Our Case Number: ABP-314724-22

Re: Railway (Metrolink - Estuary to Charlemont via Dublin Airport) Order [2022]
Metrolink. Estuary through Swords, Dublin Airport, Ballymun, Glasnevin and City Centre to Charlemont, Co. Dublin

Written Submission on behalf of Irish Life Assurance plc, the owner of the commercial office building and premises known as Cadenza, 19-20 Earlsfort Terrace and 65A Adelaide Road, Dublin 2

**Re : Railway (Metrolink–Estuary to Charlemont via Dublin Airport) Order 2022
19-20 Earlsfort Terrace (former Seagrave House) and 65A Adelaide Road (former
Davitt House)**

Drawing Title
Figure 14.6 Groundborne Noise from Operation
 Sheet 6 of 7

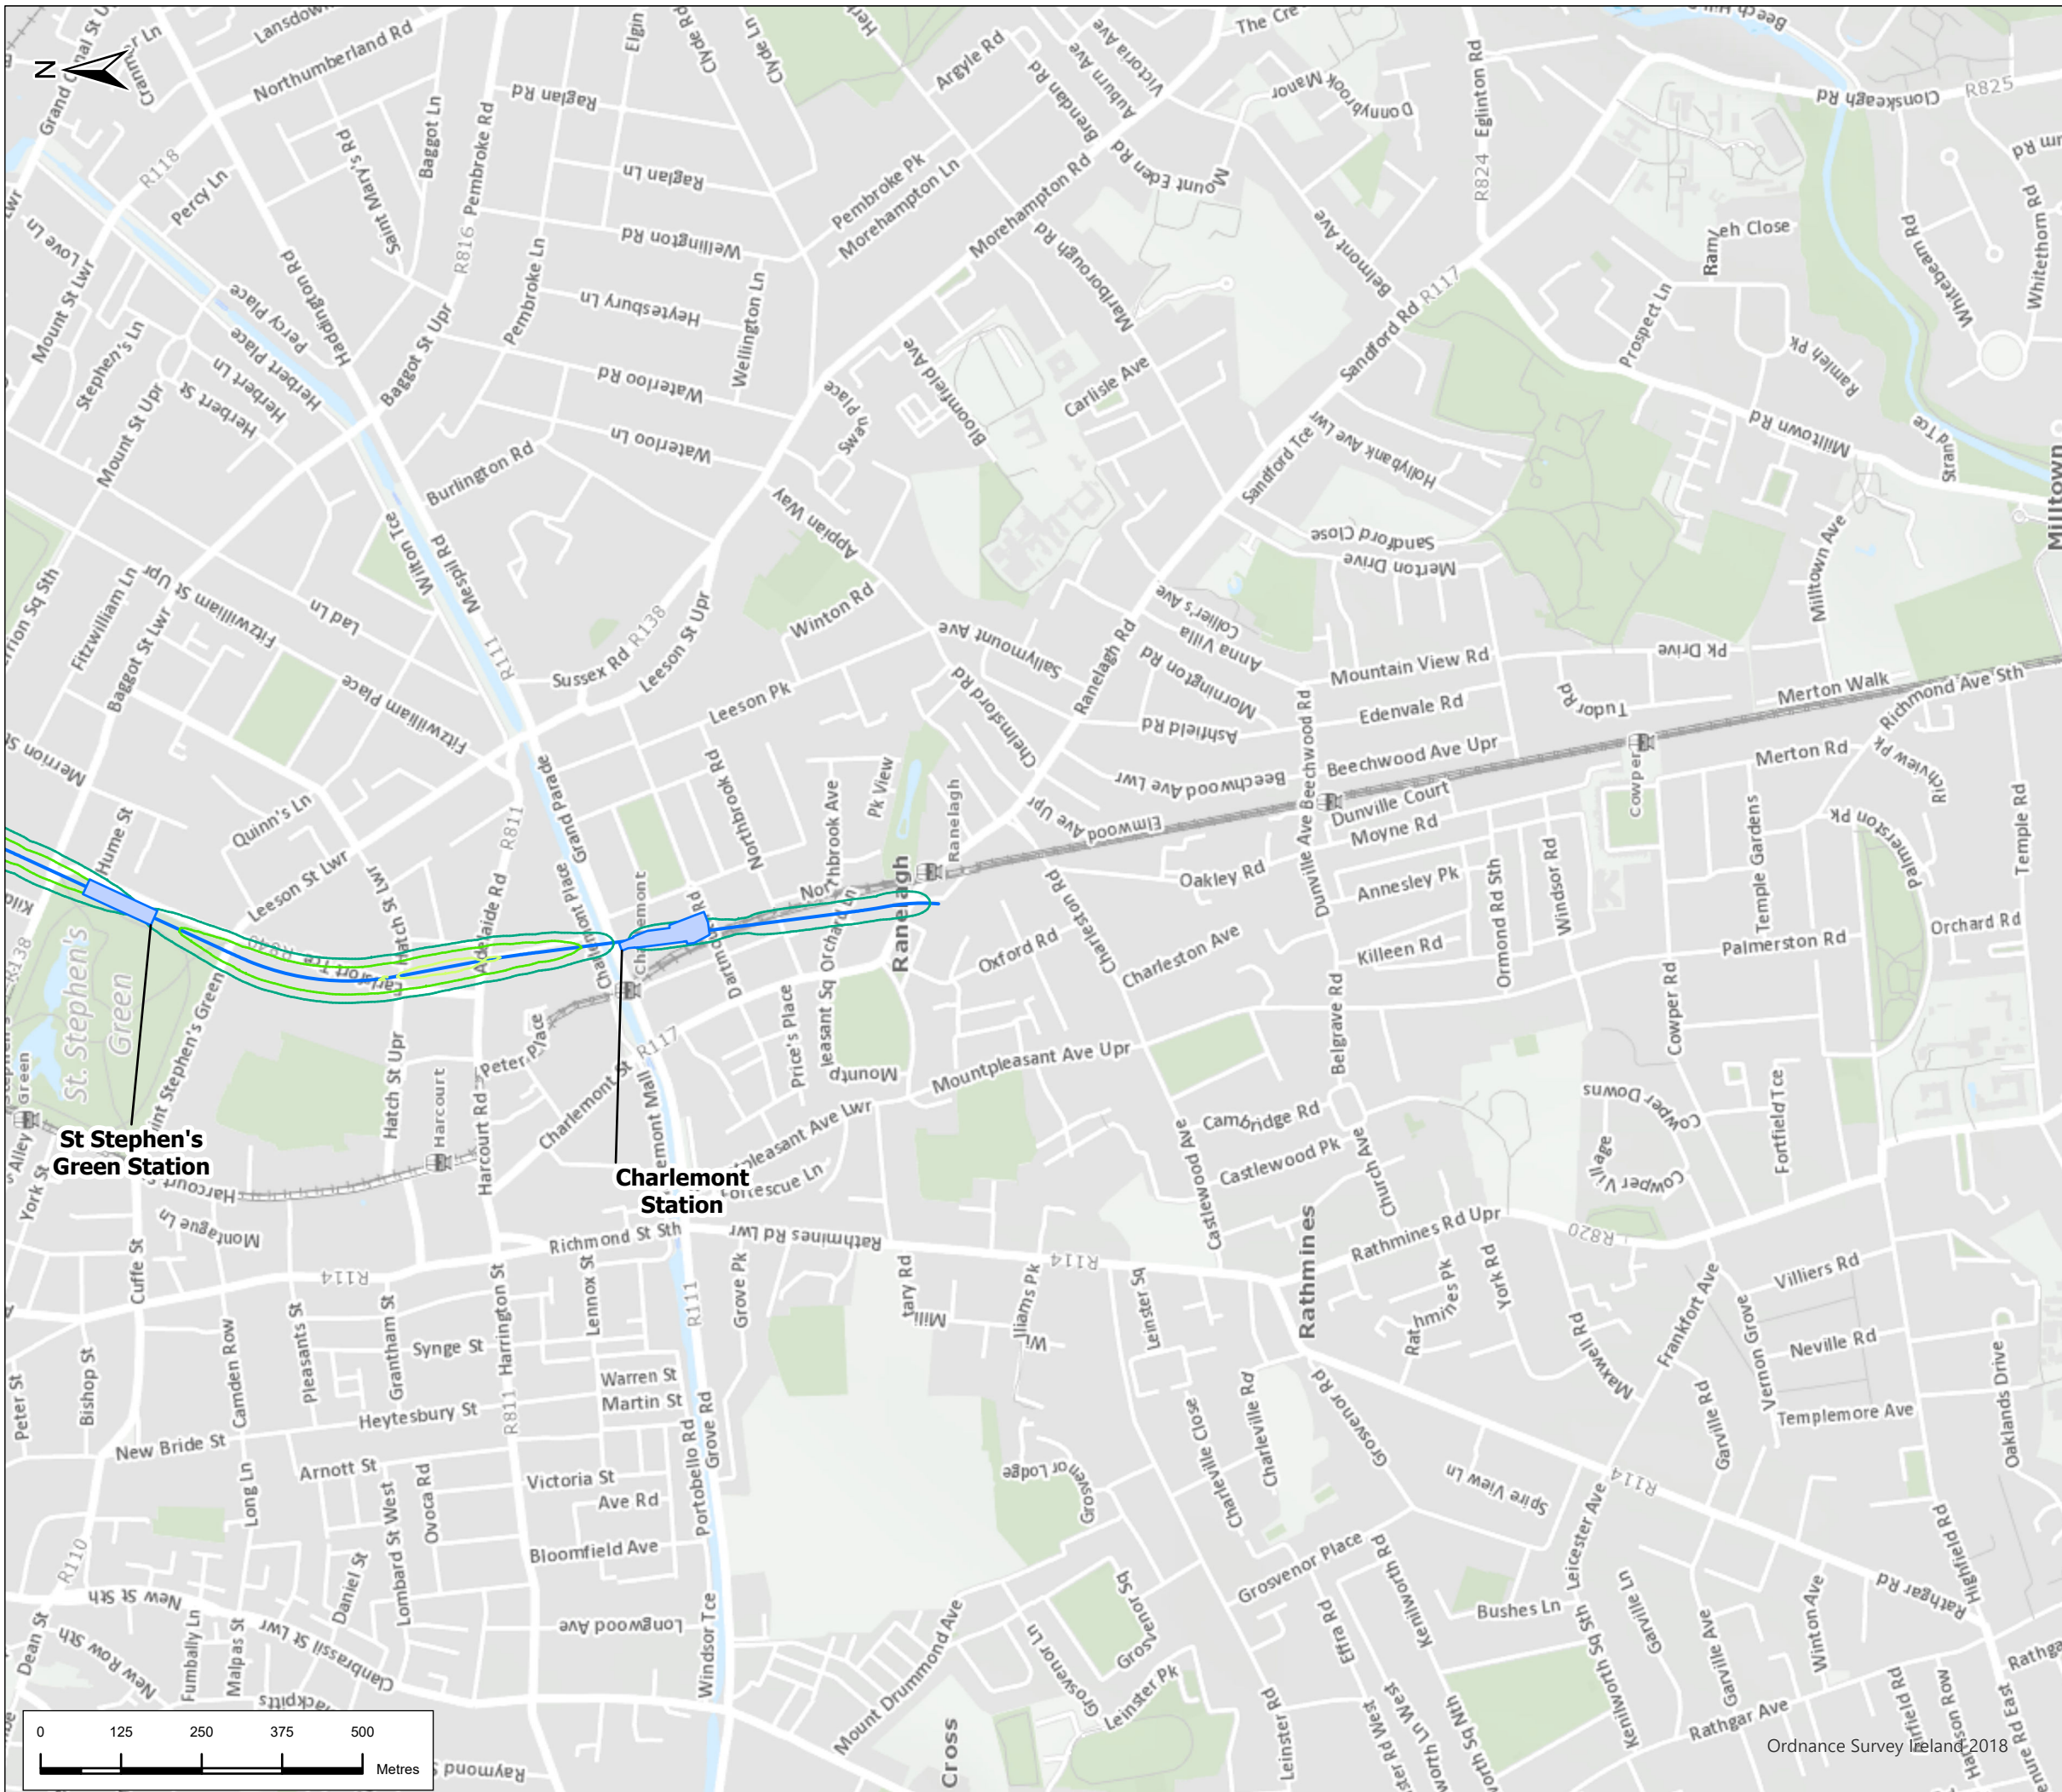
- a) Metrolink has assessed the "*Groundborne Noise from Operation*" and presented its findings on drawing no. ML1-JAI-EIA-ROUT-XX-DR-Y-14041 (a copy is attached to this submission). This drawing indicates MetroLink will be generating an additional 35db directly under the location of our Clients building which is unacceptable.
